From: [REDACTED]
Sent: 04 January 2023 09:25
To: Planning
Cc: [REDACTED]
Subject: Application 3/2022/1098 FAO Stephen Kilmartin

Re planning application : 3/2022/1098 Fir Tree House Chatburn

PLANNING APPLICATION 3/2022/1098

1 PROPOSED NORTH ELEVATION
Scale: 1:100

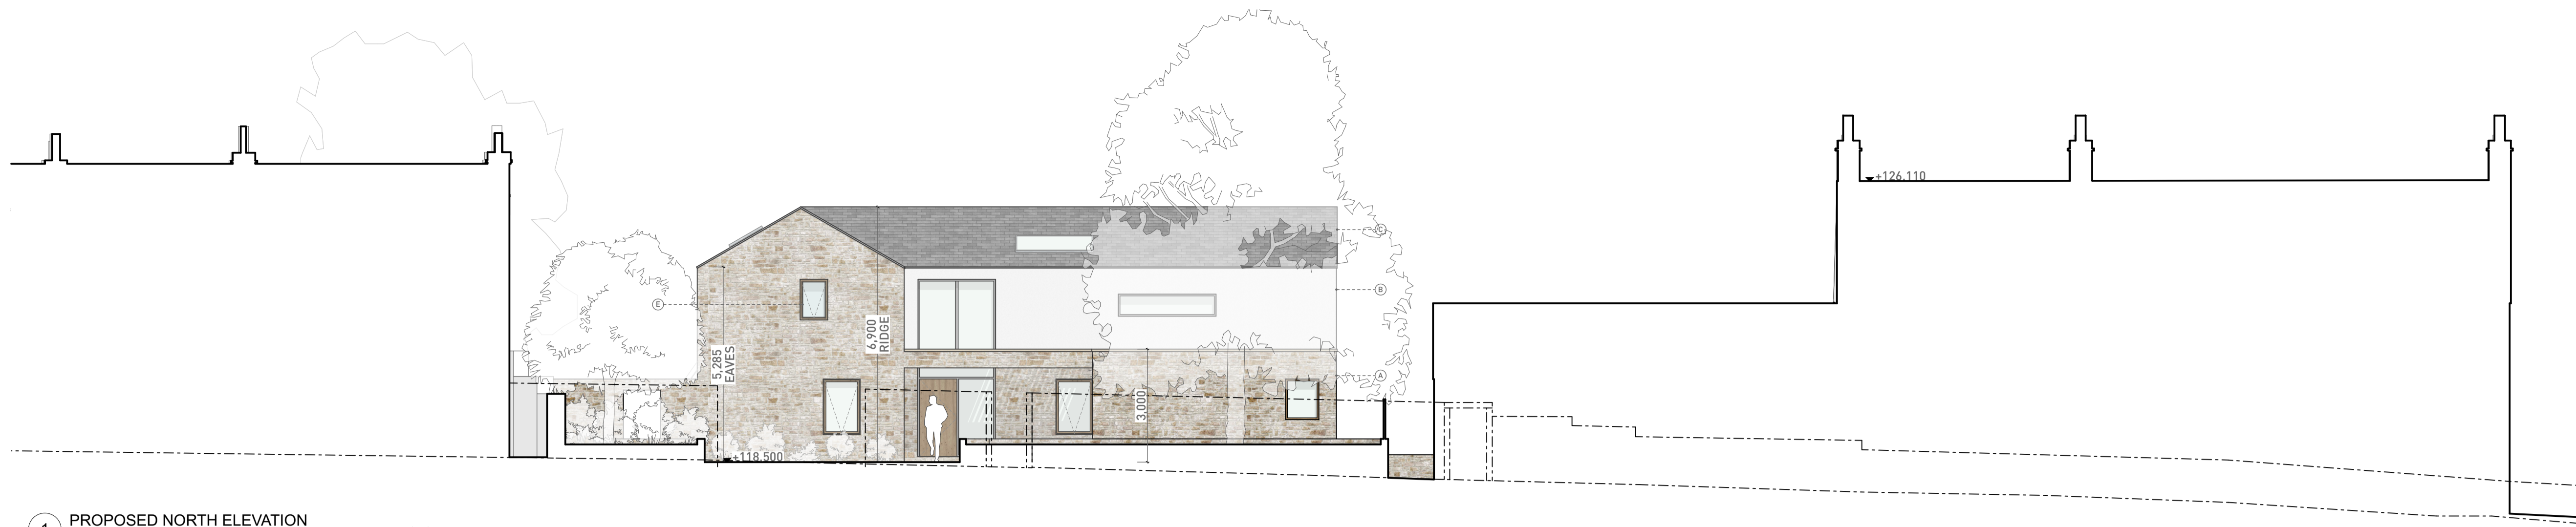
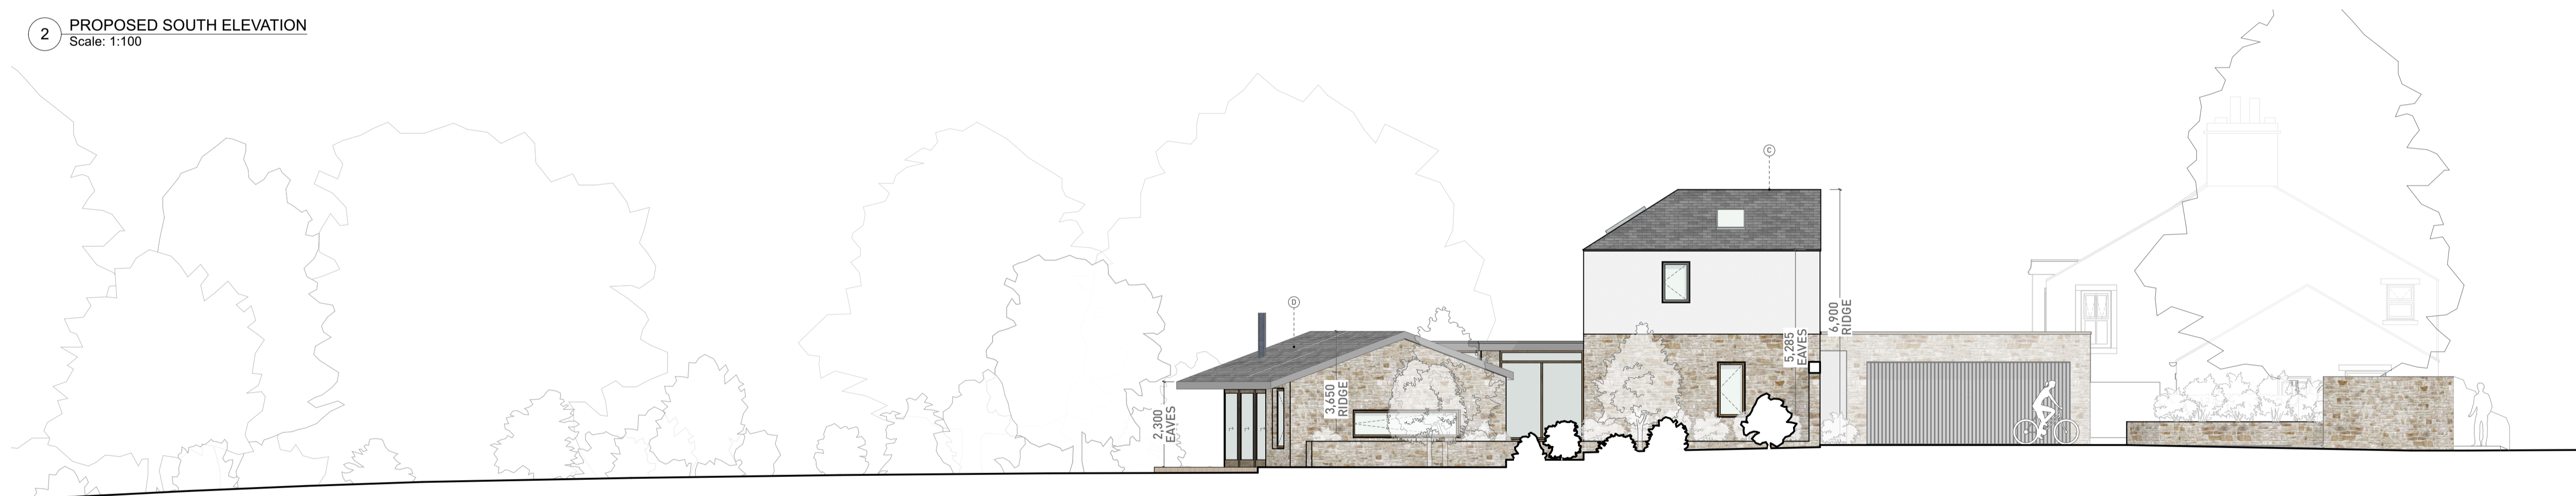
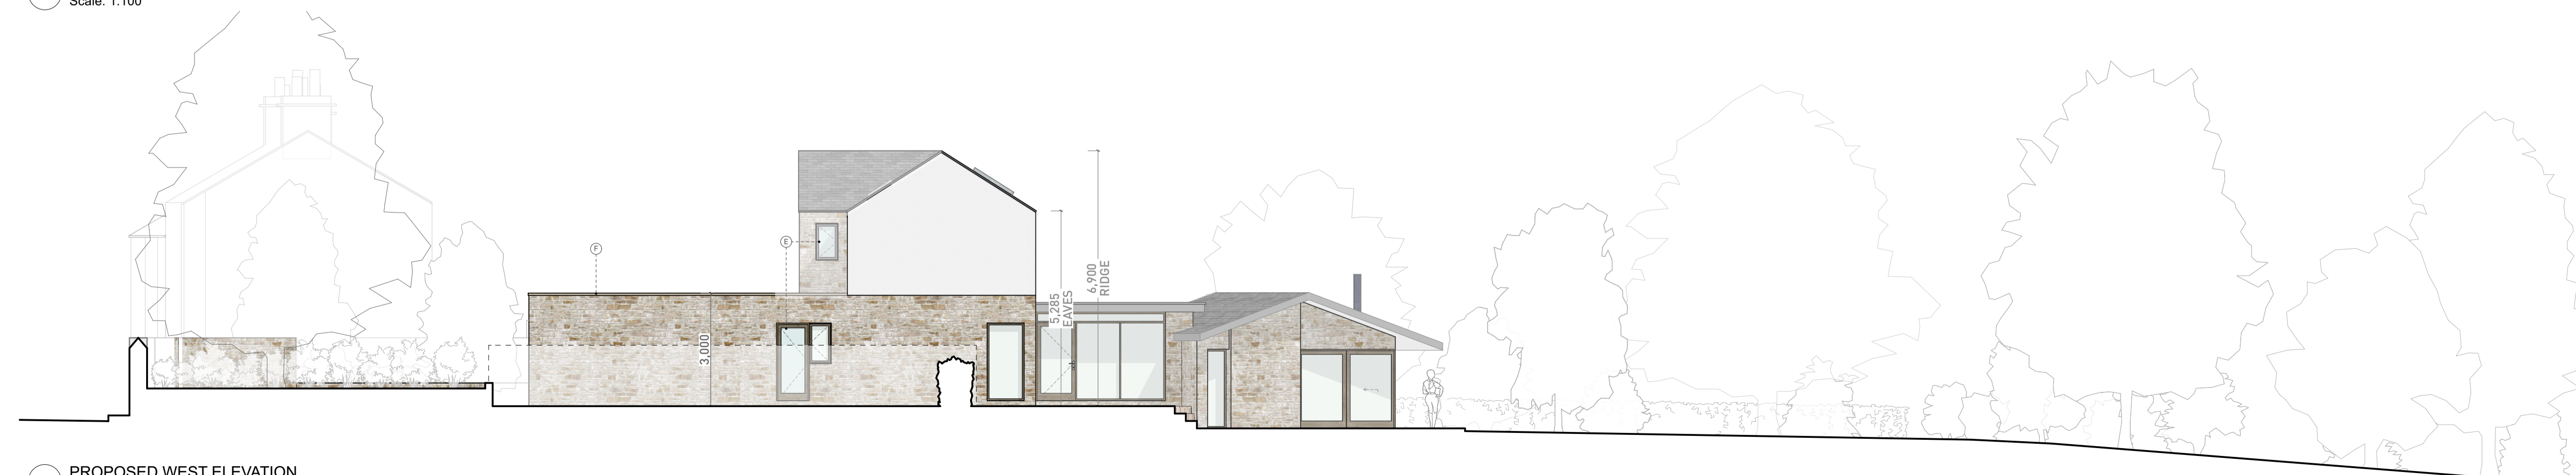
>> - The design has made no considerations for neighbouring properties whilst entitlements to light and view cannot be protected the significance of the footprint of the build and height of property will significantly change this area of the village.

>> -The size and design of the proposed scheme is not in line with the neighbouring cottages and would not add value to the conservation area as it stands. The materials are not consistent with the two neighbouring properties.

What, therefore, about the effect that the first floor development will have on the properties [redacted] Downham Road. We consider that it will be highly visible and certainly not discreet as stated

We believe that the construction will have a "Berlin Wall" effect on the visual appearance above the existing site line of the Boundary Wall.

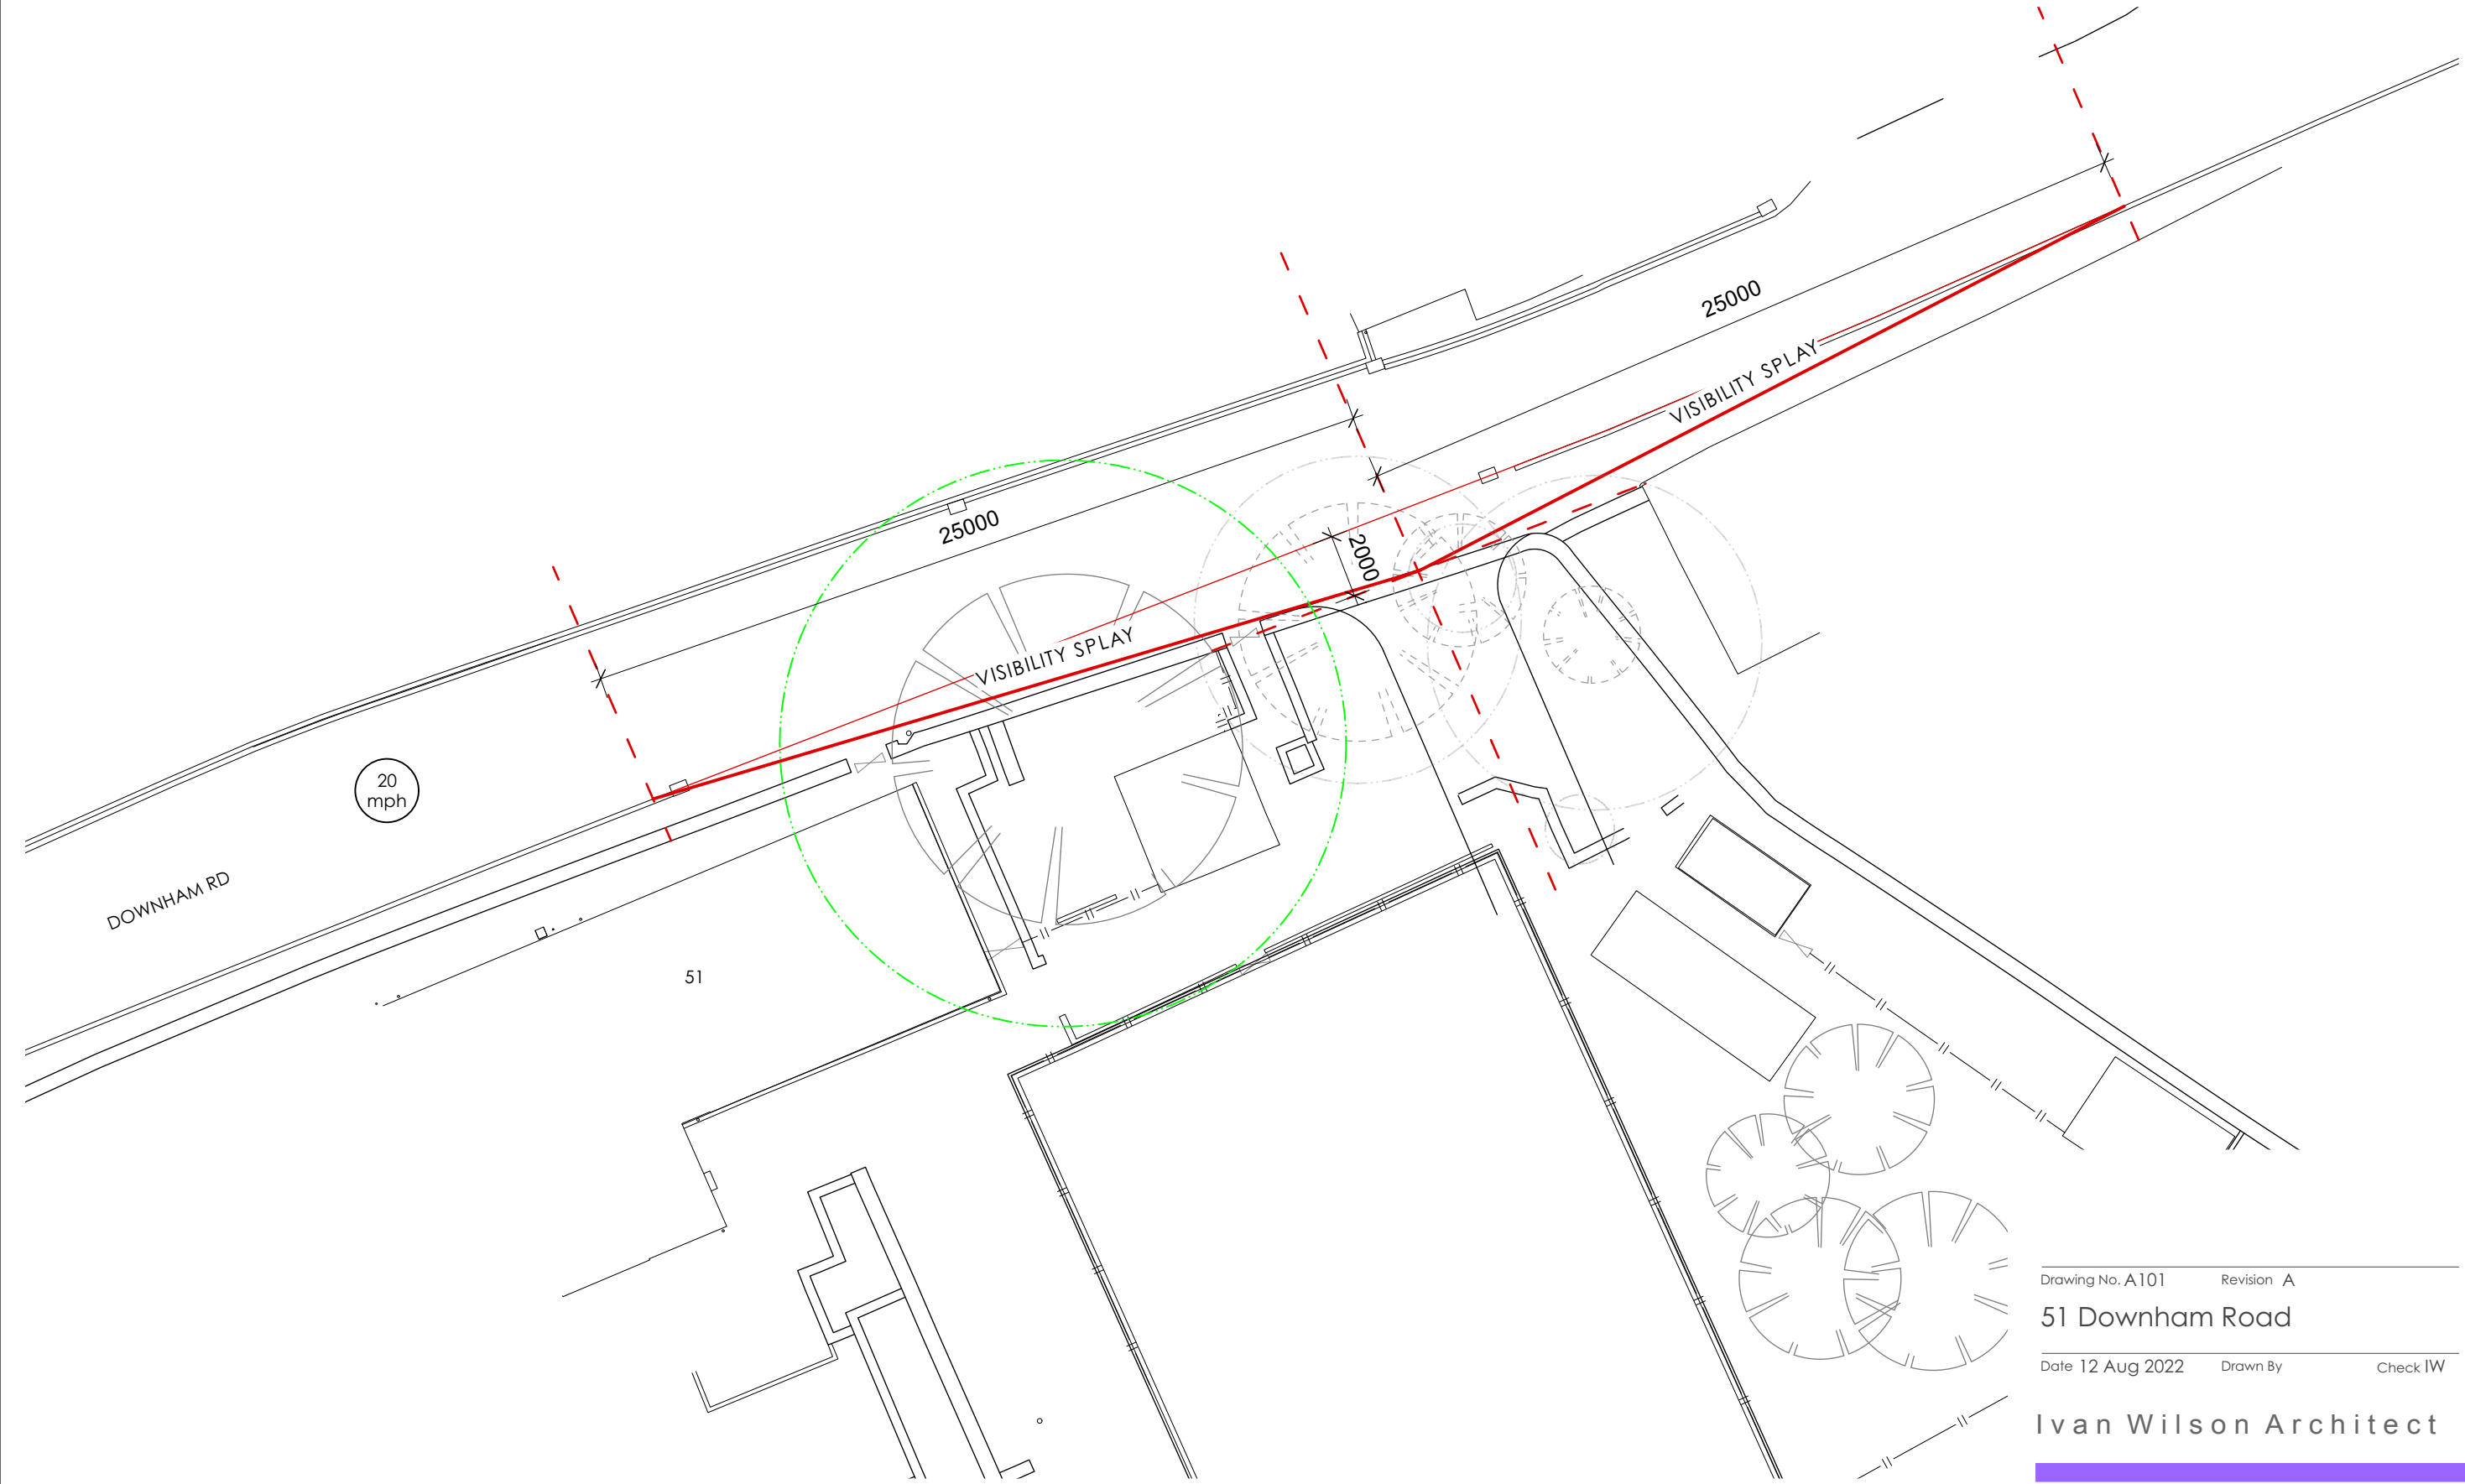
Whilst the L.C.C. have approved these developments they are based on the assumption that the 20 mph speed limit will be adhered to.

This will not be the case and the Parish Council, even after the 20 mph speed limit was introduced have asked for various types of speed restrictors but to no effect.

The entrance is badly sited if the speed limit is not followed and an accident is inevitable.
